A303 Sparkford to Ilchester Dualling Scheme TR010036

8.6 Draft Statement of Common Ground with Somerset Drainage Board Consortium

DRAFT STATEMENT OF COMMON GROUND

Location

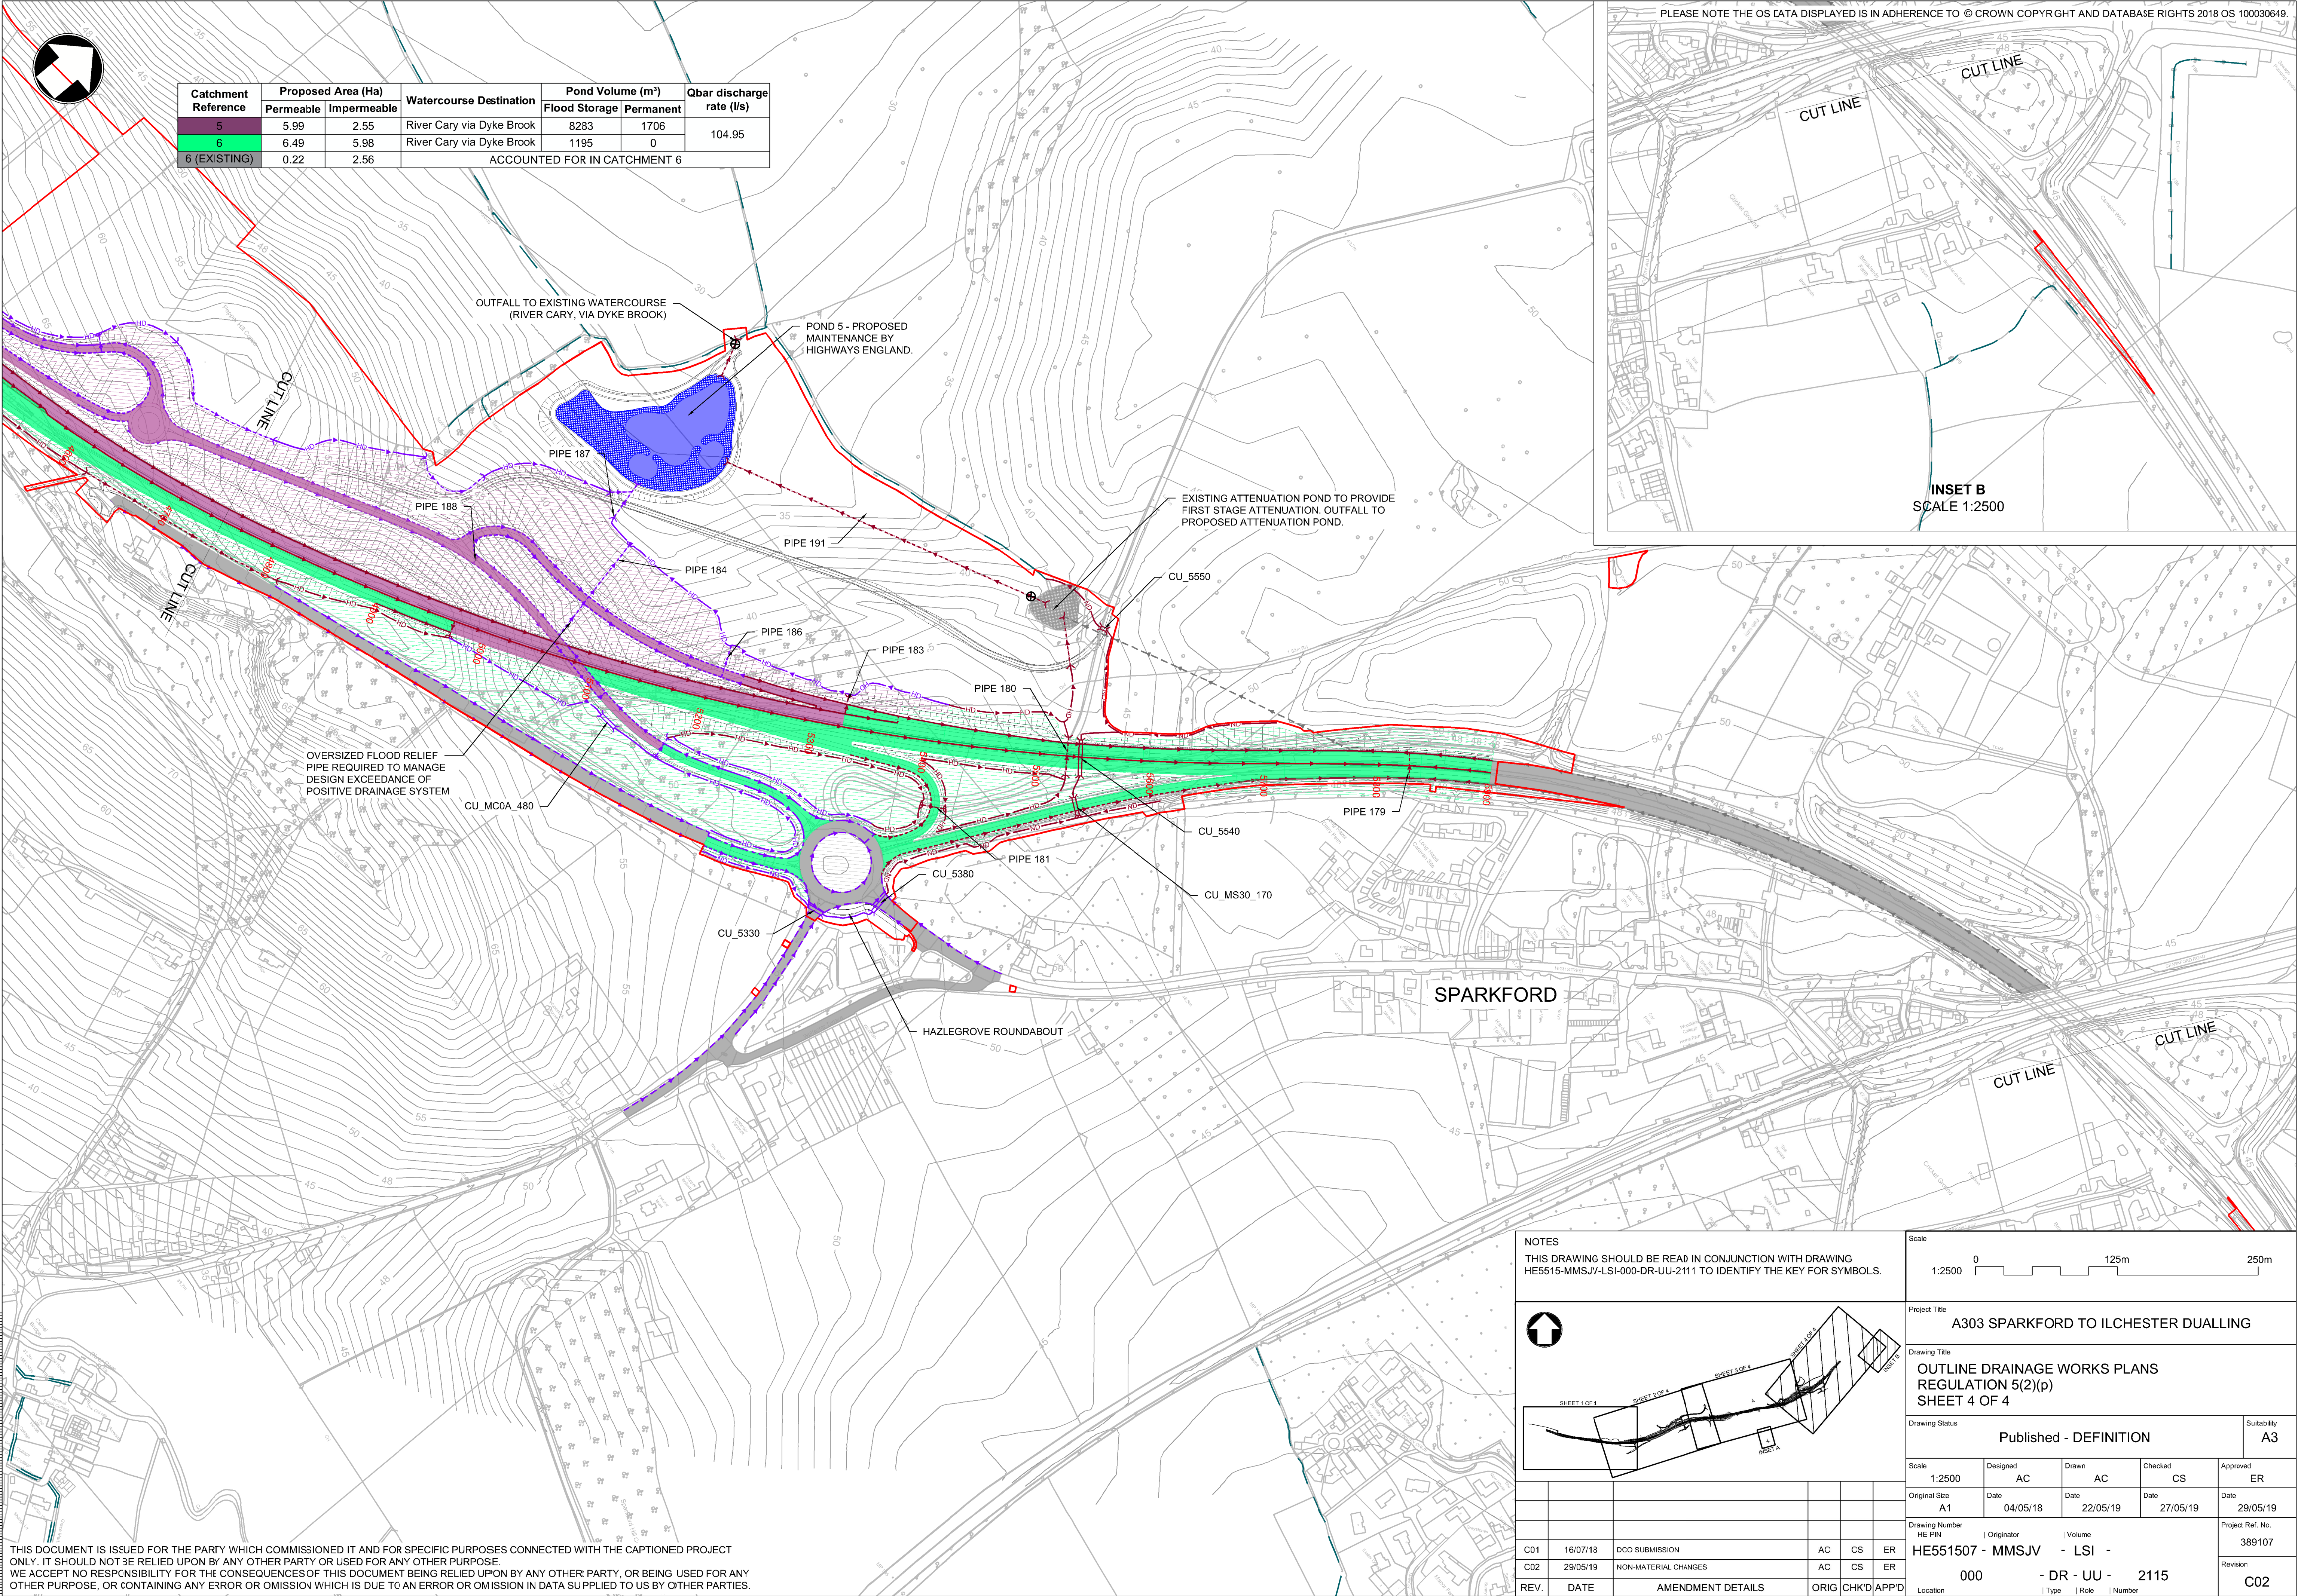
Topic	Stakeholder Comment	Highways England Response	Status
Water quantity	Confirmation is sought that the proposed design will control the overall volume, as well as the overall rate of runoff with sufficient attenuation provided.	Attenuation has been provided, with discharge limited to 1% annual exceedance probability (1 in 100-year event) plus 40% to account for the effects of climate change (Flood risk assessments: climate change allowances, Environment Agency), to no greater than the undeveloped rate of runoff, determined by the calculation of the mean annual peak rate of runoff for a greenfield site (Qbar). Preliminary design discharge rates and volumes shown in Outline Drainage Works Plans (APP-106).	AGREED
Water quality	Confirmation is sought that the proposed pond design provides effective water quality treatment with the use of a permanent water level, and that this volume is sufficient in size. It is recommended that the SuDS Manual (C753) is referred to in the calculation of these permanent volumes, as well as the detailed design of the forebays and vegetation that will be essential for water treatment.	A permanent water level has been provided for each of the proposed ponds. The volume of treatment has been provided in accordance with the SuDS Manual (C753) - '10-15 millimetres of rainfall depth falling over the contributing catchment'. Accepted. Appropriate planting has been considered as part of the landscaping assessment and design. Attenuation feature discharge rates and volumes shown in Outline Drainage Works Plans (APP-106).	AGREED

Topic	Stakeholder Comment	Highways England Response	Status
		As in accordance with Outline Drainage Works Plans (APP-106).	
Maintenance and access	<p>There is concern that there is not adequate space provided for adequate and effective maintenance of the ponds and ditches.</p> <p>It is recommended that maintenance tracks are provided, ensuring connectivity to the ponds and ditches.</p> <p>To undertake a full de-silt of the ponds a maintenance strip greater than 4m is required. Further information needs to be supplied on this at the detailed design stage.</p>	<p>A grassed 4 metre maintenance strip has been provided around each pond and along each ditch. Additional access tracks have been provided to provide access to the ponds.</p> <p>As in accordance with Outline Drainage Works Plans (APP-106).</p>	UNDER DISCUSSION
	<p>There is concern that the maintenance tracks do not provide access to the control structures, which would need to be maintained and accessed in the event of a large pollution incident.</p>	<p>Accepted.</p> <p>The ponds and maintenance tracks have been redesigned to provide access to these structures.</p> <p>Access shown in Outline Drainage Works Plans (APP-106).</p>
